DNDEN00043A

**4490 EAST BLANEY RD
PEYTON, CO 80831**

CONSTRUCTION DOCUMENTS

**COMPOUND, ACCESS &  
ENLARGED SITE PLANS**

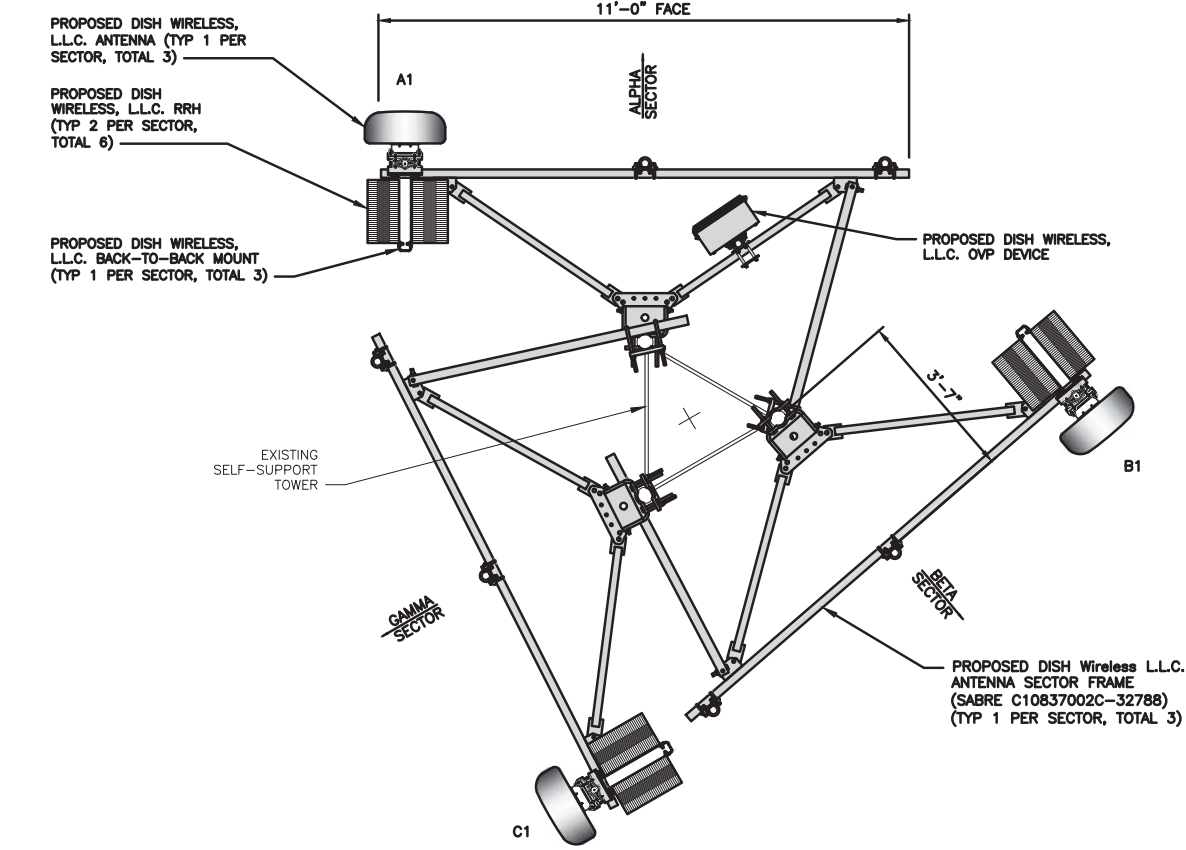
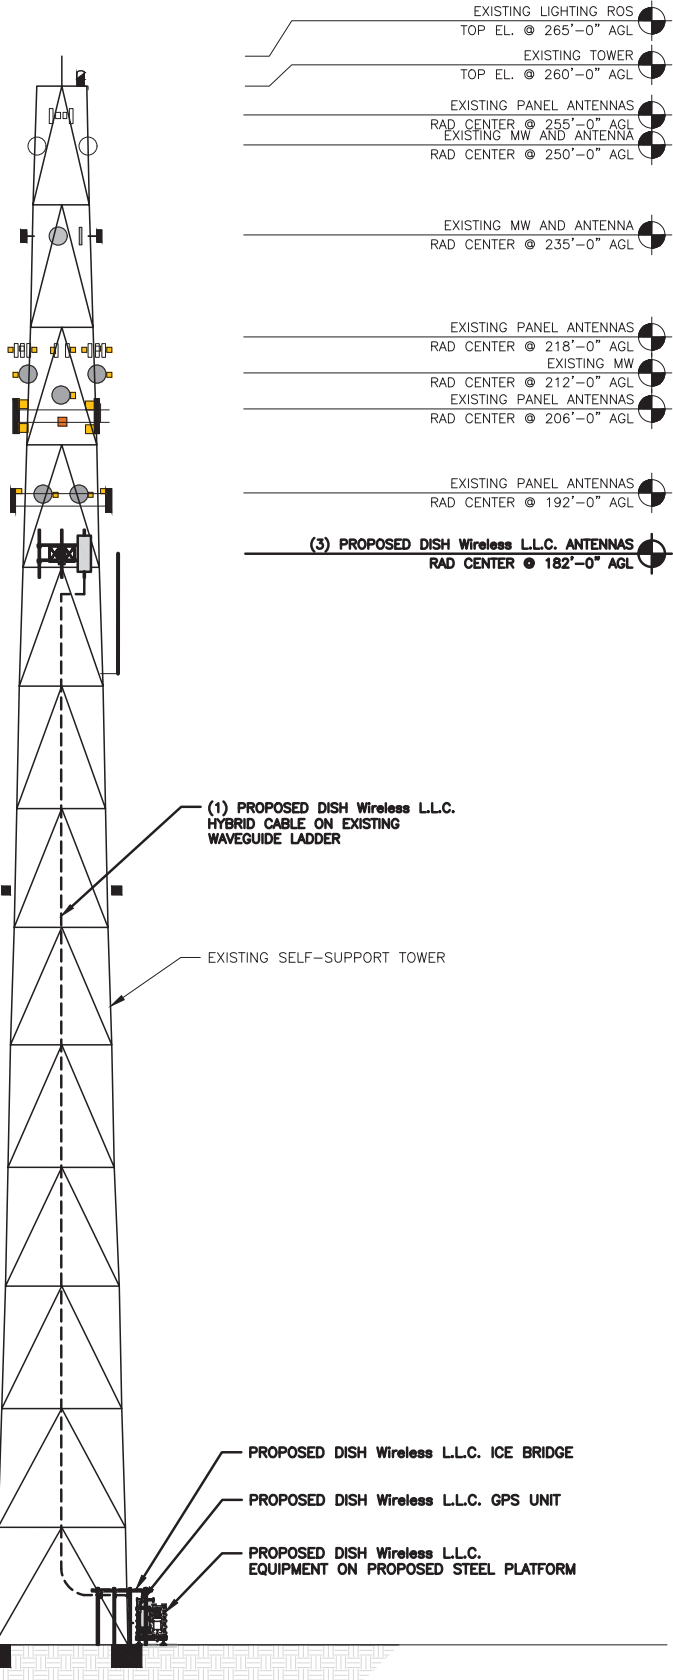
PREVIOUS REDLINES

please add the following to the site plan:

- Lot/parcel size
- Existing/proposed land use
- Location and dimension of the all property lines
- The setback distances from each existing and proposed structure to the property lines
